RE: Lytle Boundary Line Adjustment (BL-19-00016)

All applicable departments have reviewed your Boundary Line Adjustment application (BL-19-000016), and have determined that an updated site plan is required for adequate review (see attached Public Health comments).

TO: Chelsea Benner – Planner I, Community Development Services
FROM: Candie Leader, Administrative Assistant
DATE: October 16, 2019
SUBJECT: BLA BL-19-00016 (Lytle)

**RECORD OF SURVEY**  
 A PORTION OF THE W 1/2 OF THE SW 1/4 OF SECTION 3,  
 TOWNSHIP 19 NORTH, RANGE 14 EAST, W.M., KITTITAS COUNTY, WASHINGTON

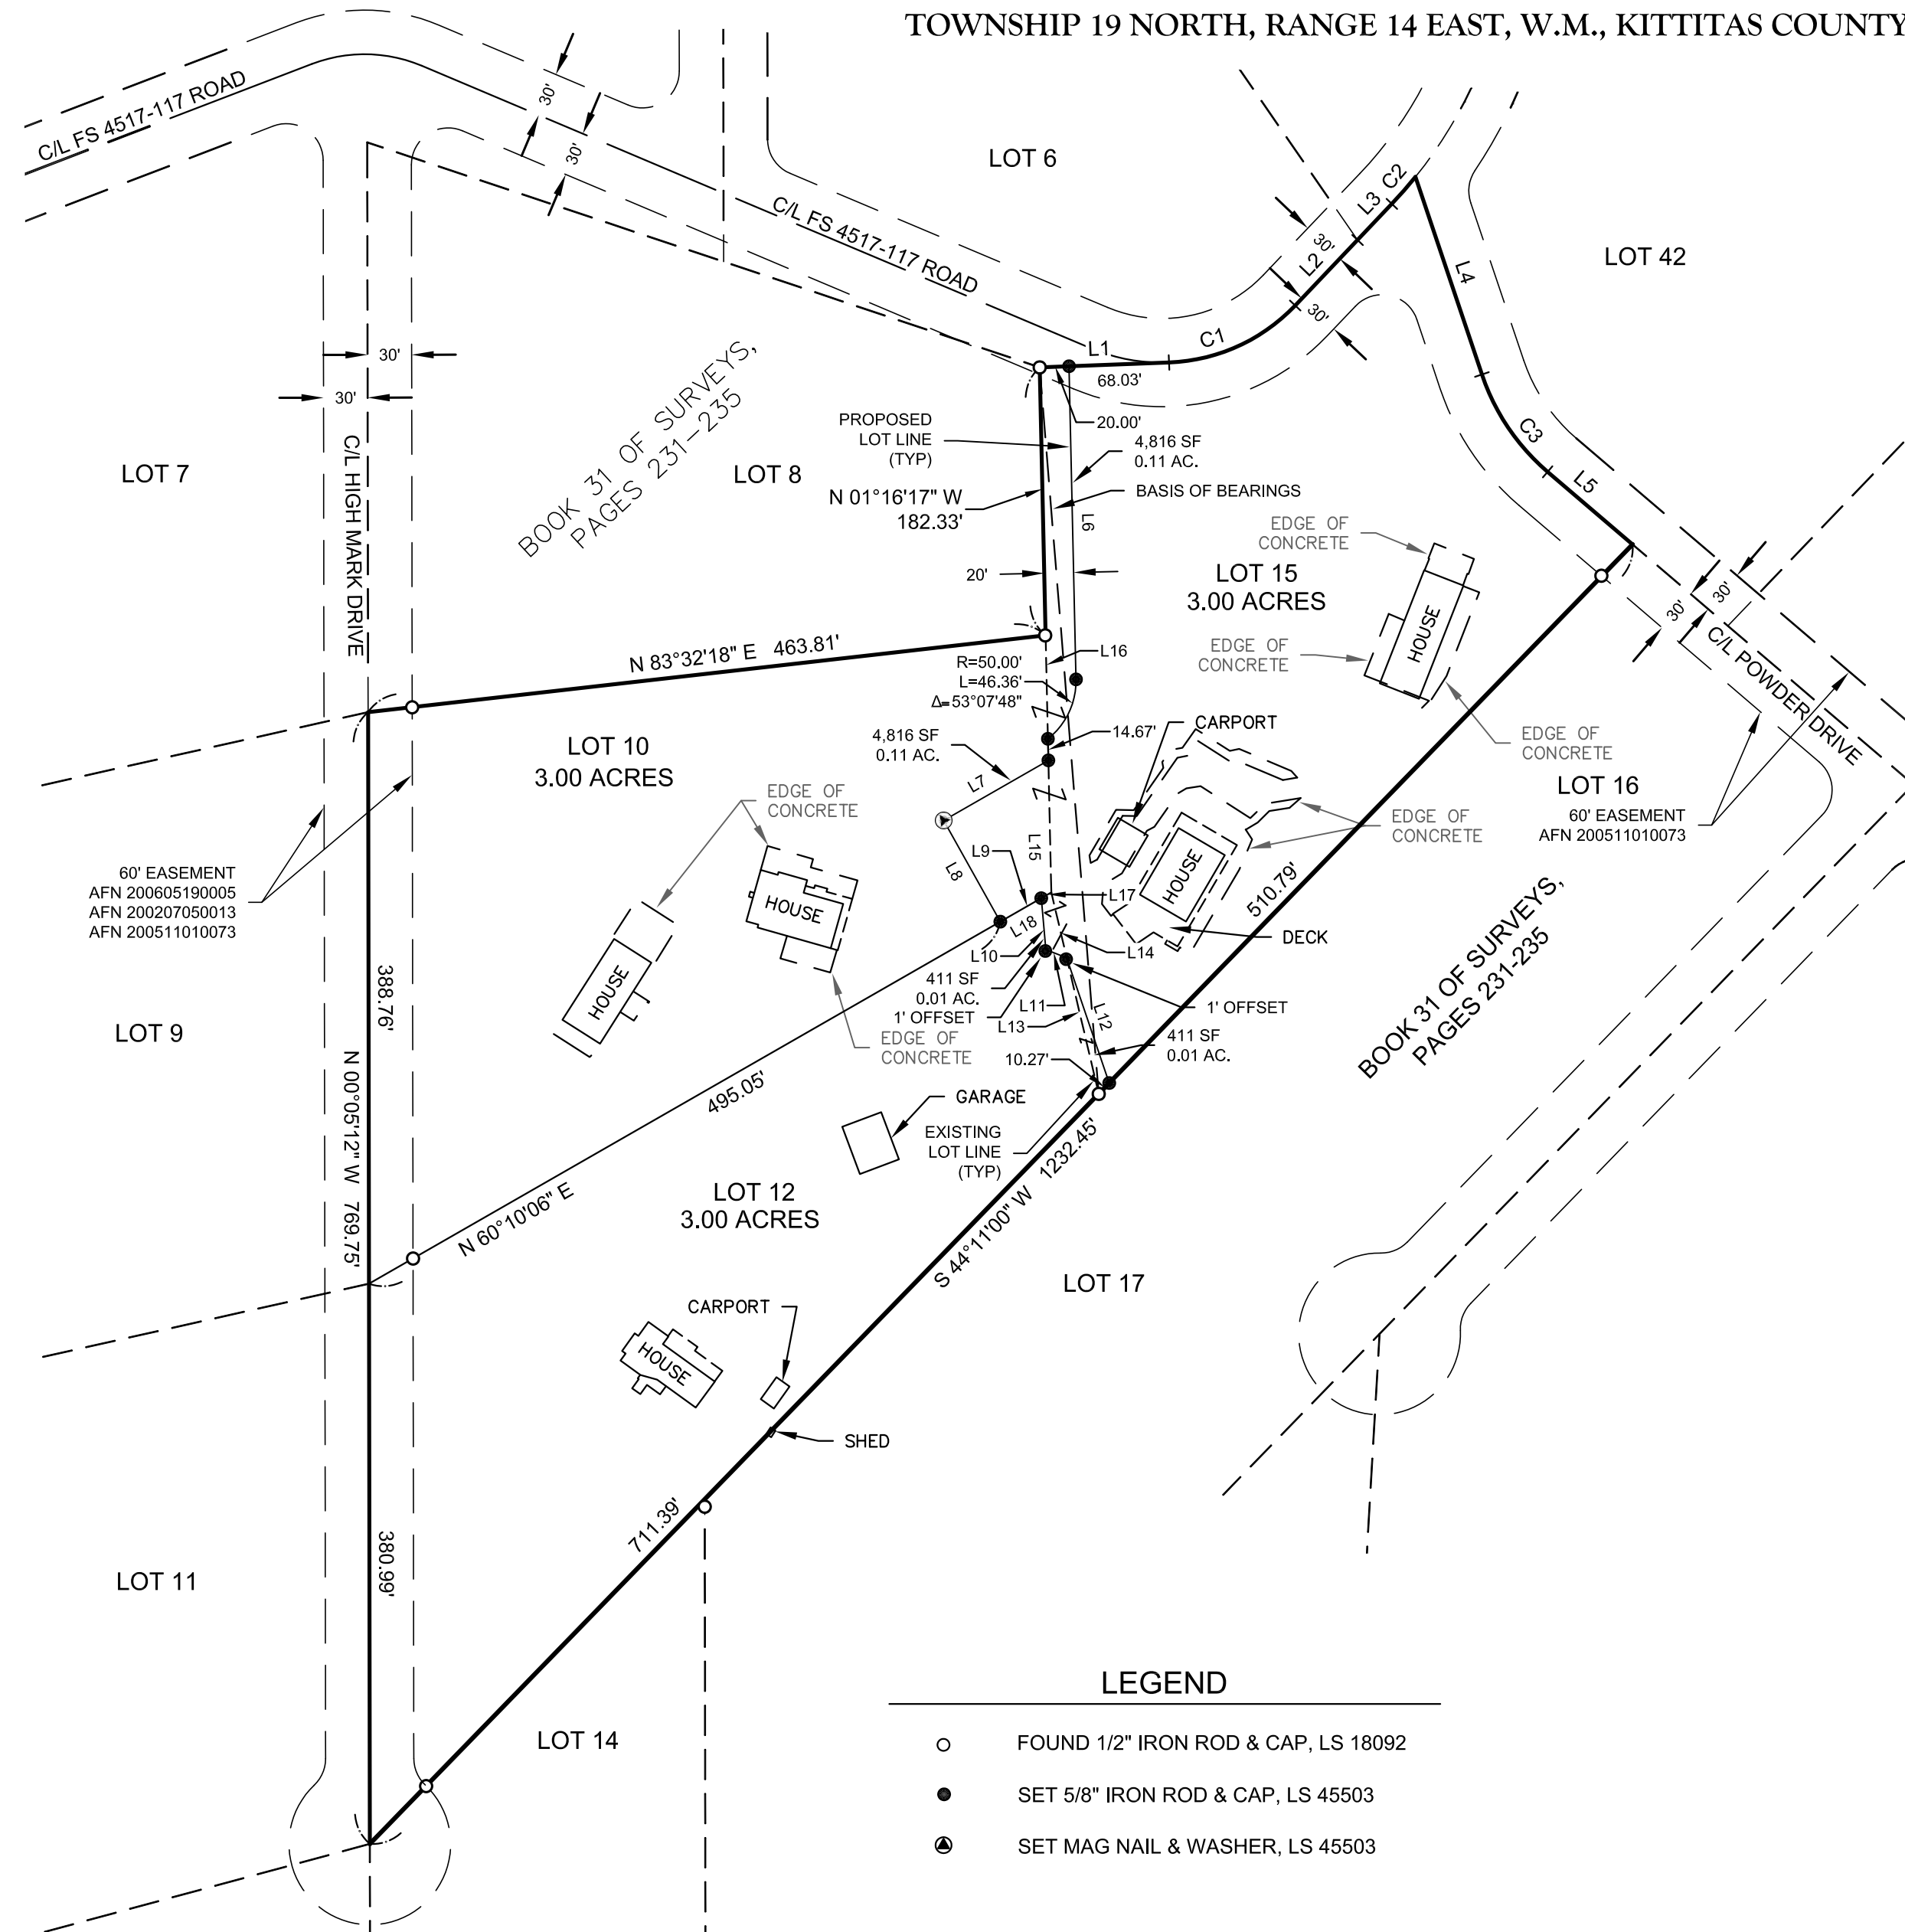
1. Individual septic system locations
2. Well locations

After reviewing the file it is noted that the parcels are served by individual septic systems and individual/shared wells. I need to see a site plan showing the locations of all wells and drainfields to enable me to complete my review.

1. The Section Township and Range should be shown at the top of the page (all sheets).
2. The Map is not stamped and signed by a surveyor licensed to practice in Washington State.

3. The following statements will need to be included as part of the final BLA:
 - Surveyor's Statement
 - Auditor's Statement
 - Survey Equipment and Procedures statement
 - Purpose of Survey Statement
 - Basis of Bearing Statement (if not shown on face of map)
 - An elevation Datum statement (or remove reference to elevations from map)
4. The Map should include a Legend.
5. The dimension on the North Line of Lot 12 obscures adjacent text.
6. The Southeasterly lines of Lot 12 and 15 should clarify what is being dimensioned.
7. As an accepted minimum, the new lot lines should have corners set in the field, and noted on the face of the map.
8. Lot 15 contains an elevation reference on a 4" PVC. This should be removed or a reference to the source and datum of the elevations be included (see note 3 above).
